Notice of Exhibition of application for Intercontinental Hotel Alterations and Additions (SSD-7693-Mod-2)

Tim Smith OAM
Director, Heritage Assessments
Heritage NSW
Department of Premier & Cabinet
As Delegate of the Heritage Council of NSW
24/2/2022

SITE PLAN
 TITLE
 JOB NO 6680
 DWG NO 1001
 ISSUE A

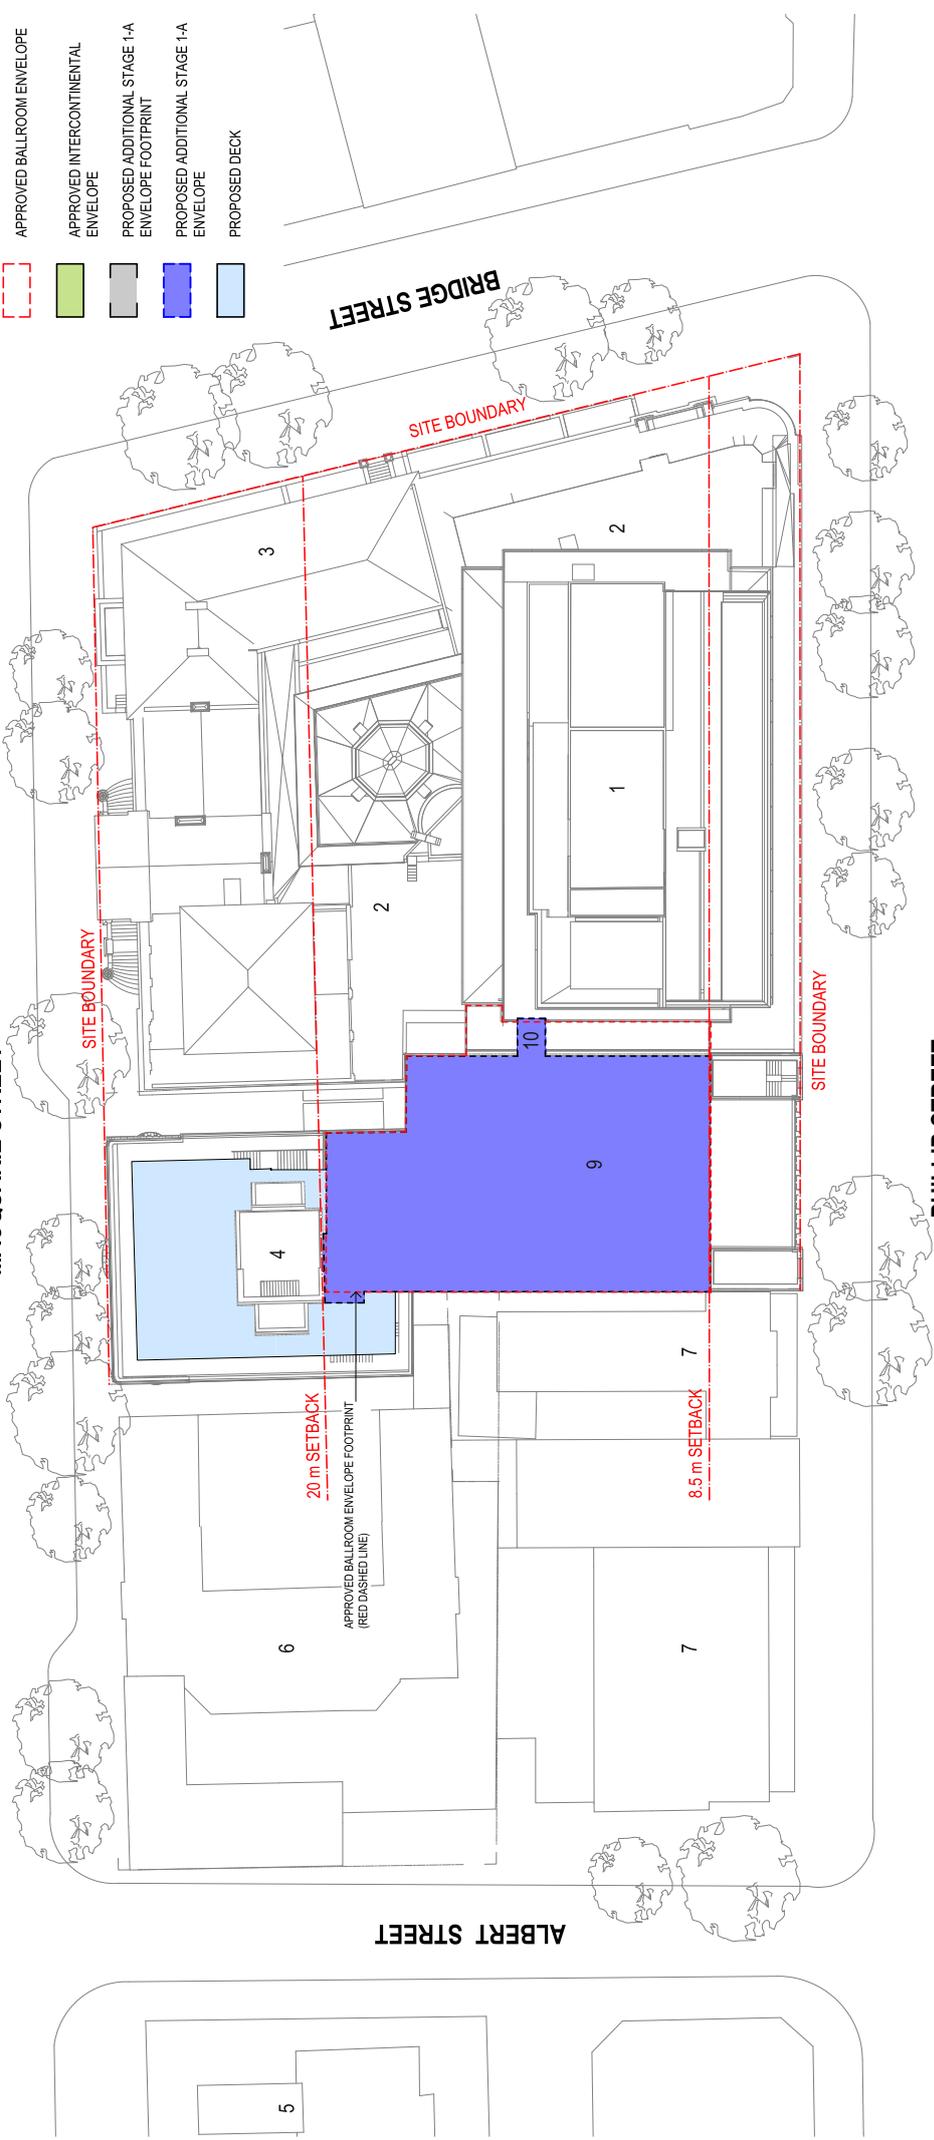
- The proposed deck, balustrade etc. were not part of the previous approval. The works are within the 20m setback imposed by the Independent Planning Commission and so may be in contravention of the previous approval. These works will have an adverse

heritage impact in terms of view, setting and integrity. There is likelihood of further impact of associated works probable to follow, such as shade structures, lighting, seating, roof top landscaping, etc. In view of the above, the proposed deck is not supported. The drawings do not indicate the setback of the glass balustrade from the existing parapet which needs to be clear.

PROPOSED ADDITIONAL STAGE 1-A ENVELOPE: SECTION A

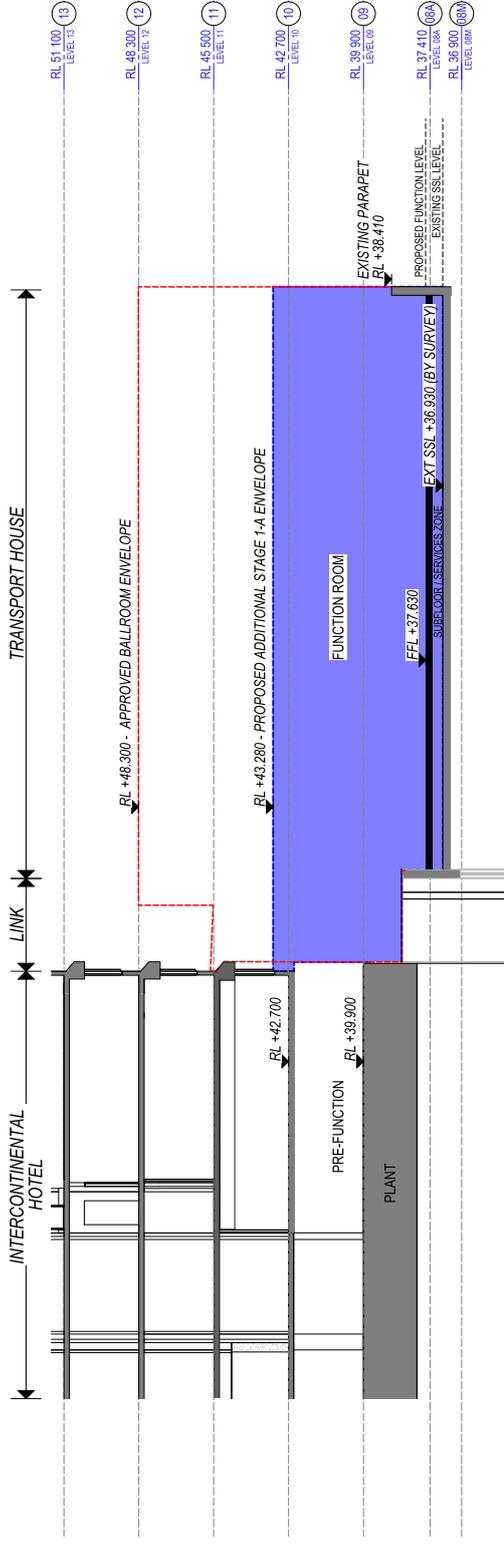
- The proposal describes the addition as a single storey even though the proposed height is 6.35m. It should be clarified whether the proposed envelope will comprise one or two floors.
- The addition is proposed to be a temporary structure intended to be prefabricated. The proposal should include confirmation that the works will be easily reversible. Any associated structural works should only be to enable a single-storey structure.
- The proposed addition is described as an interim 'stage' so there is a possibility that the original approval is executed by adding another storey atop the temporary structure. There is also a risk that the original approval is not executed and the temporary structure is perpetuated. These will in effect allow bypassing of the conditions of consent. These risks as well as the 10-year time-limit should therefore be addressed through conditions of consent.
